**Subject:** RE: AB/109/20

ADDITIONAL COMMENTARY

NORTHERN ELEVATION

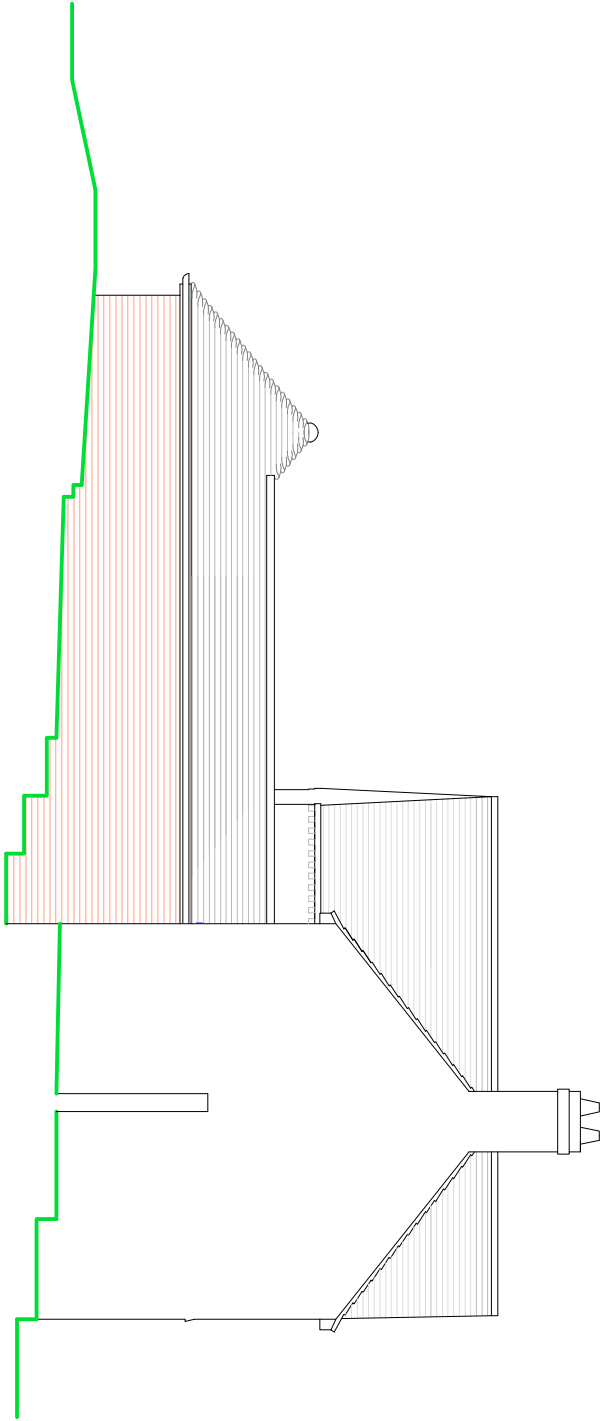
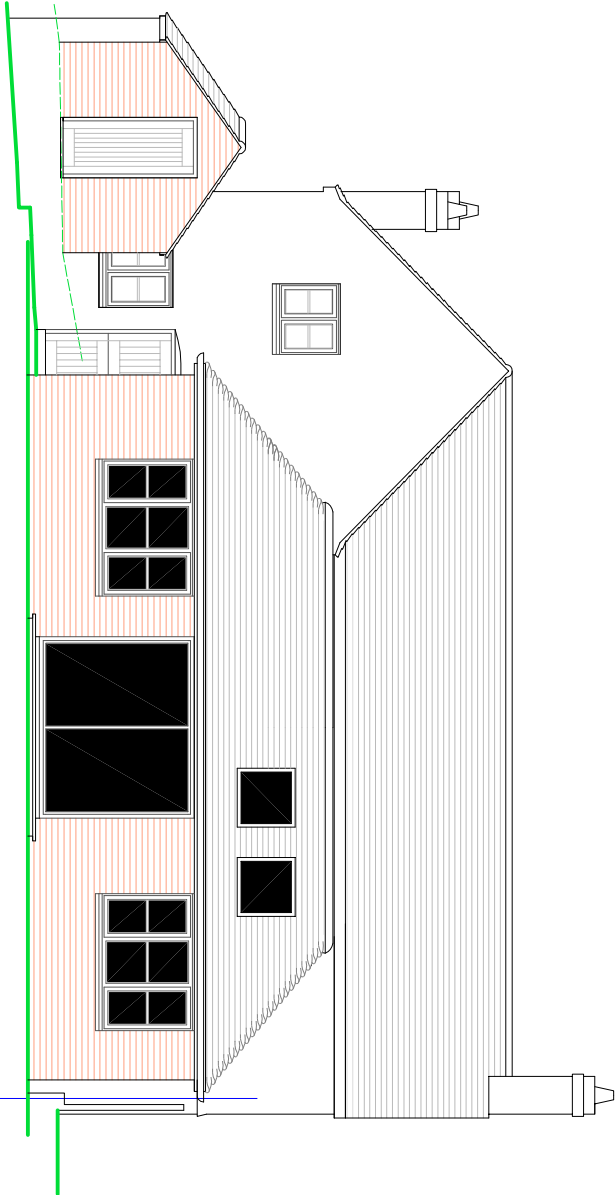
At present an existing hedgerow provides a boundary for the application site and the neighbouring property to the north (no. 36). The proposed extension would be located close to no. 36 King Street and would require the loss of part of this hedgerow which provides separation between the two properties. It appears to be a fairly substantial hedge. However, it is assumed that it could be removed and replaced by an alternate means of enclosure without the need for the submission of a planning application, as the dwelling subject of this application is itself not listed.

The removal of the hedgerow would open up this part of the garden to the neighbouring listed building, which would mean that the proposed extension would be visible from the rear amenity space of the neighbouring property. However, I note that the applicant has indicated on the plans that some form of means of enclosure would be provided. Further, I also note that the 'Agent supporting Document' contains the following: 'The extension has been designed so as to not sit directly on the boundary line and has allowed for enough space for planting suitable to cover the new brick wall if this is the neighbour's preference'. The re-introduction of mature hedging would help to reduce and soften the impact of the extension, although this could be enhanced by ensuring that more of the existing hedge remains. Details of the boundary could be conditioned, should you be minded to approve the application. The use of high quality, traditional materials/colours will also help.
